**RE: Submission on the proposed Culcairn Solar Farm (400MW)**  
**Lots 70-73, Lot 86 on DP753764, Lots 9-11, 45-47, 53, 54 on DP753735, Lot 1 on DP179854, Lot 114 on DP664997, Lot 1 on DP575478, Lot 1 on DP171815, Lot 1 on DP945904, Lot B on DP972054**

Thank you for the opportunity to review and provide comment on the proposed Solar Farm near Weeamera Road, Culcairn. This APA submission updates previous letter advice dated 16 May 2019.

APA's submission has been provided following review of the Layout Plan prepared by Iberica Engineering, dated September 2019, Index B. Specifically pages 1 of 4 of the layout plan where APA's easement is outlined on Lots 54 on DP753735 and Lot 1 on DP575478 near PVs 44, 54, 55, 56, and 61-64. APA notes the provision that all buildings including panels are located off APA's easement and inclusion of a 10-metre setback from APA's easement, which generally aligns with the proposed fencing. APA is supportive of the proposed layout subject to further review of the proposal during the detailed design phase. The information provided below and conditions of approval, have been provided to assist in this regard.

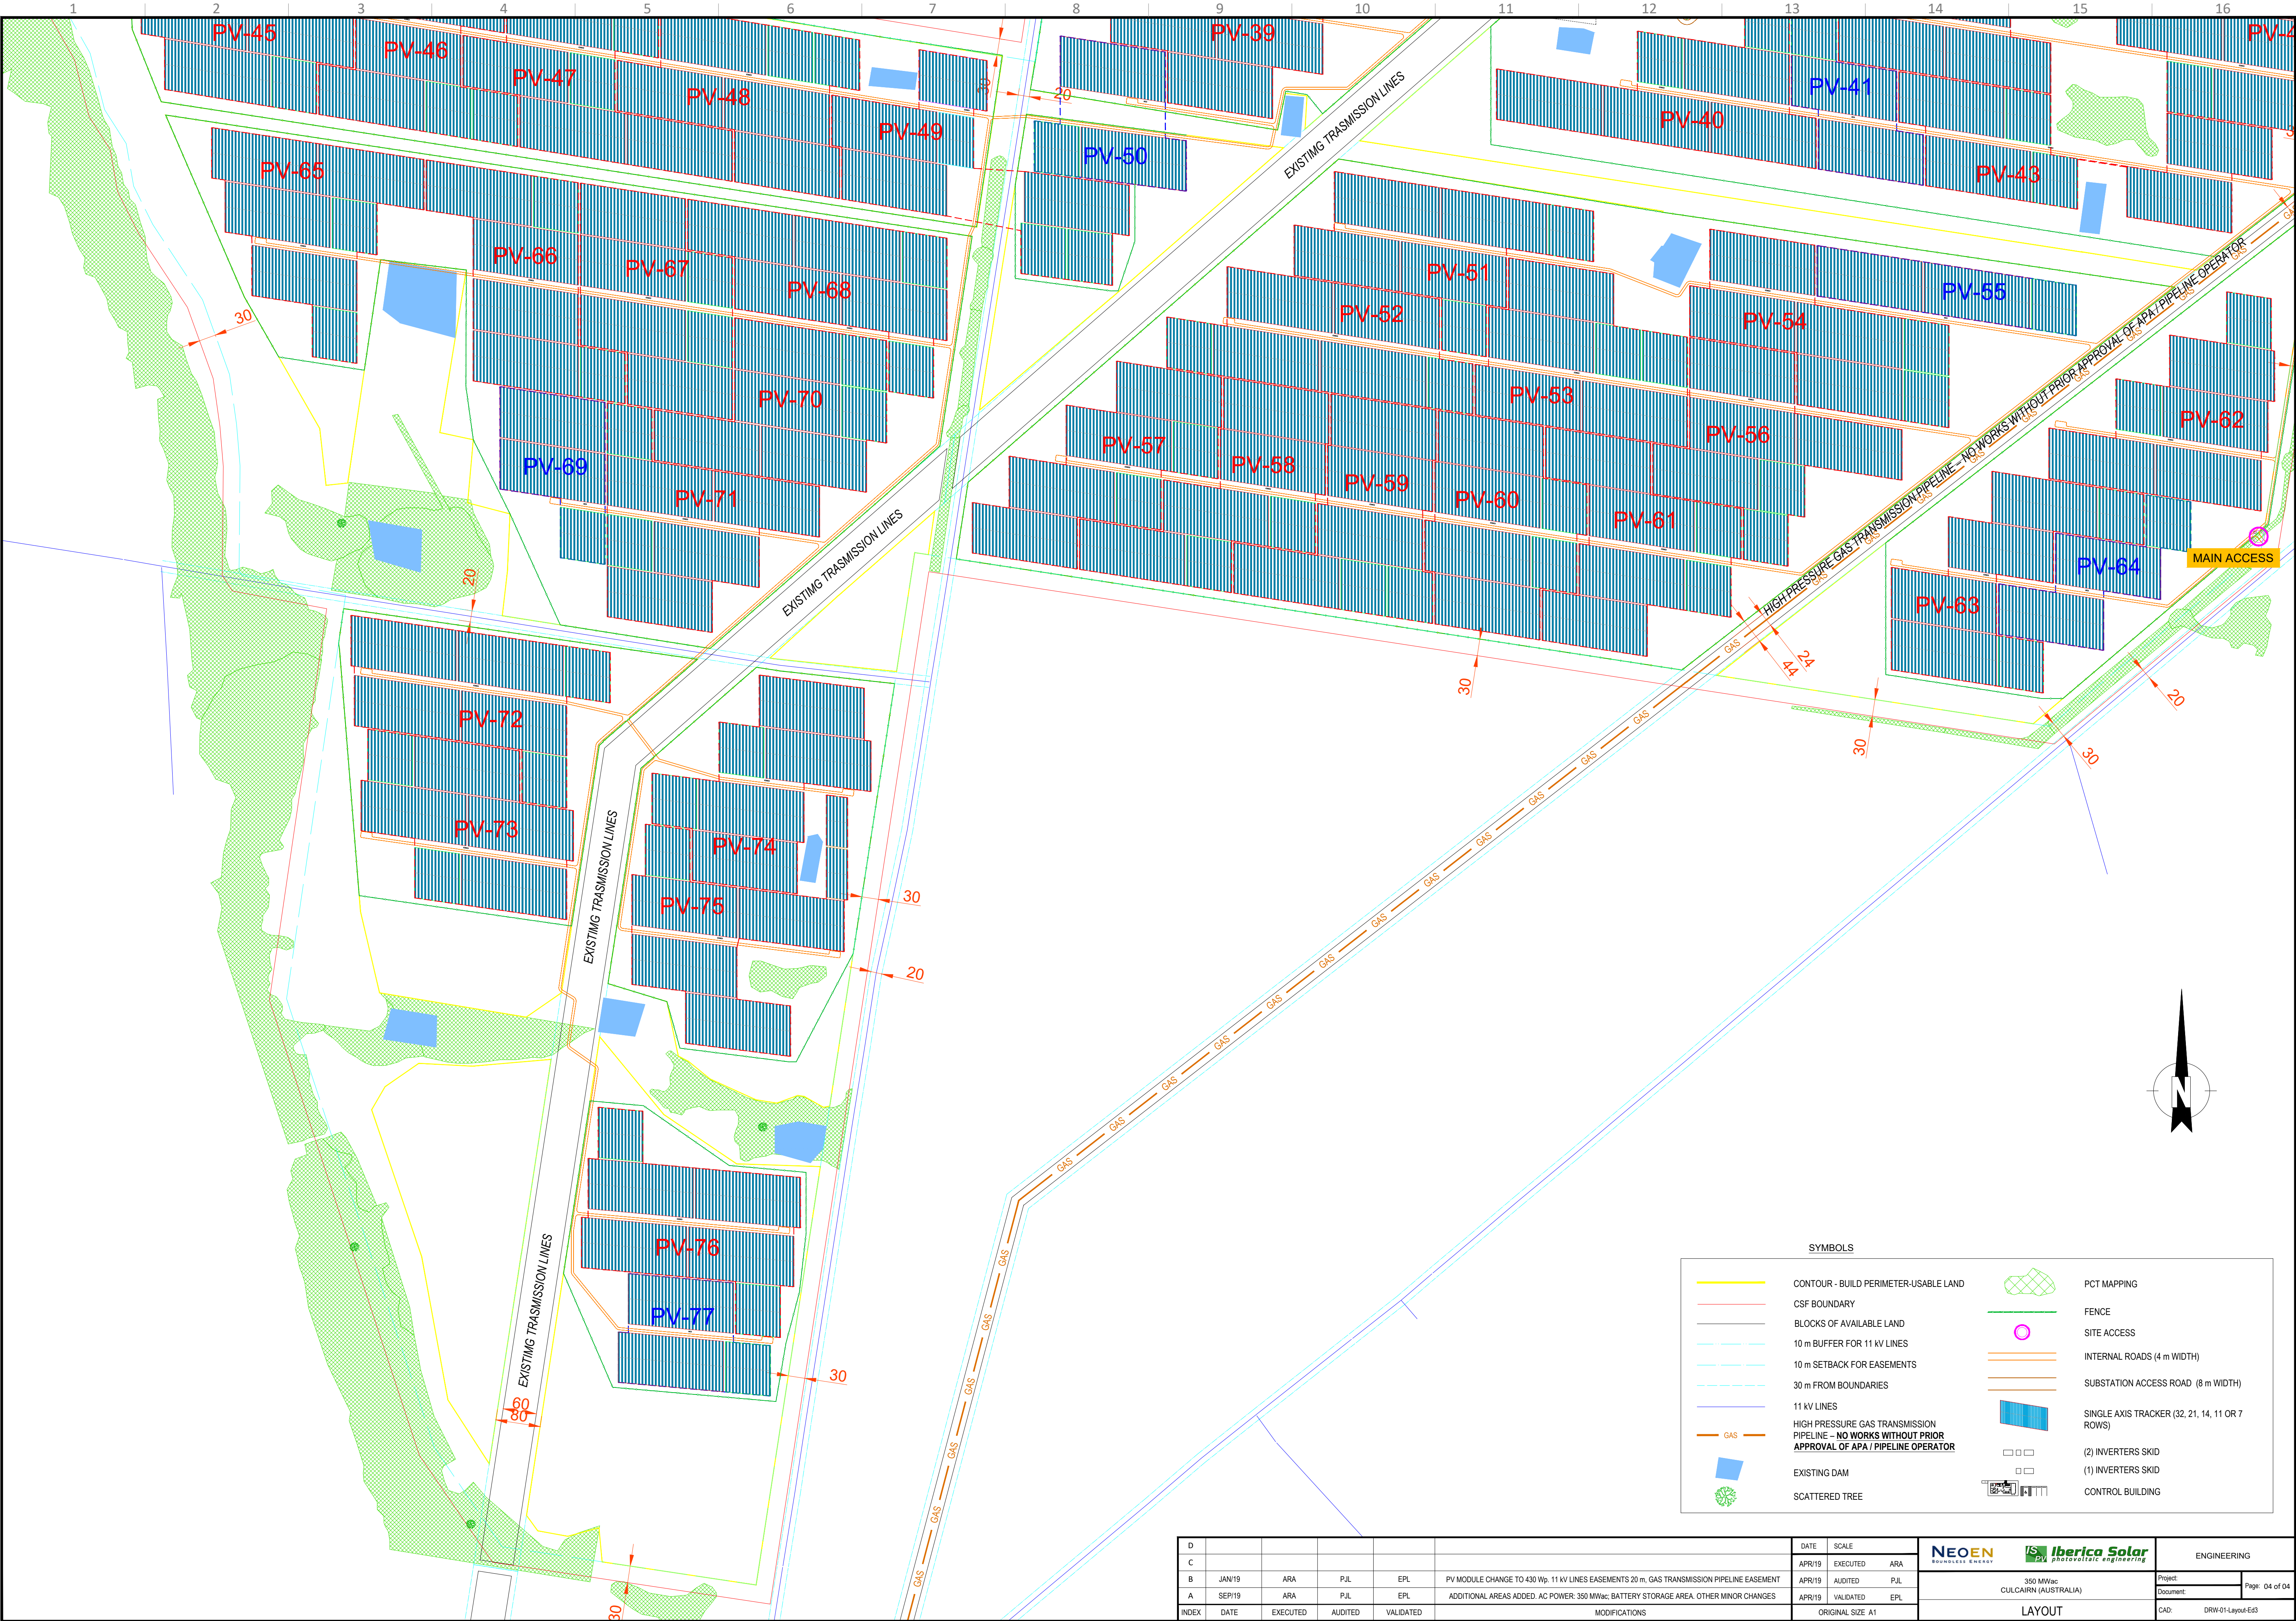
APA appreciates the requested notation of *'no works to occur without the prior authorisation of the pipeline operator'* for APA's pipeline easement on the above-mentioned layout plan. To ensure an appropriate level of risk is communicated for those undertaking site works.

All proposal plans must clearly show APA's pipelines and easement, labelled as 'high pressure gas transmission pipelines – no works without prior approval of APA'.

The proposed development is expected to have significant areas of panels to both the north and south of the pipeline easement, and there is anticipated to be the need for crossings of the pipeline. These include:

APA seeks to minimise the number of crossings and have these perpendicular to the pipeline if possible. This should include the co-location of road and services crossings. No work on the easements, including crossings, changes in ground level or other works, may occur without the prior authorisation of APA. Detailed design for crossings will need to be informed by field works to positively locate the pipeline (alignment and depth). Such field works must only be performed under APA permit.

For the proposed subdivision of Lot 54 on DP753735 to create the substation land parcel. The current pipeline easement must be transferred to the new title for proposed 'Lot E', and our current easement rights will be retained in relation to the proposed 'Lot E'.

Buildings, structures, roadway, pavement, pipeline, cable, fence, on-site waste water treatment (or irrigation area), or any other improvement on or under the land within the gas transmission pipeline easement must not be constructed without prior consent in writing from APA. No structure or vegetation will be permitted on the easement that prohibits maintenance of line of sight along the pipeline easement.

All plans which include the area of the gas pipeline easement must have the easement clearly identified with hatching on the full width of the easement. The easement must also be clearly labelled as *'high pressure gas pipeline easement – no works to occur without the prior authorisation of the pipeline operator'*.
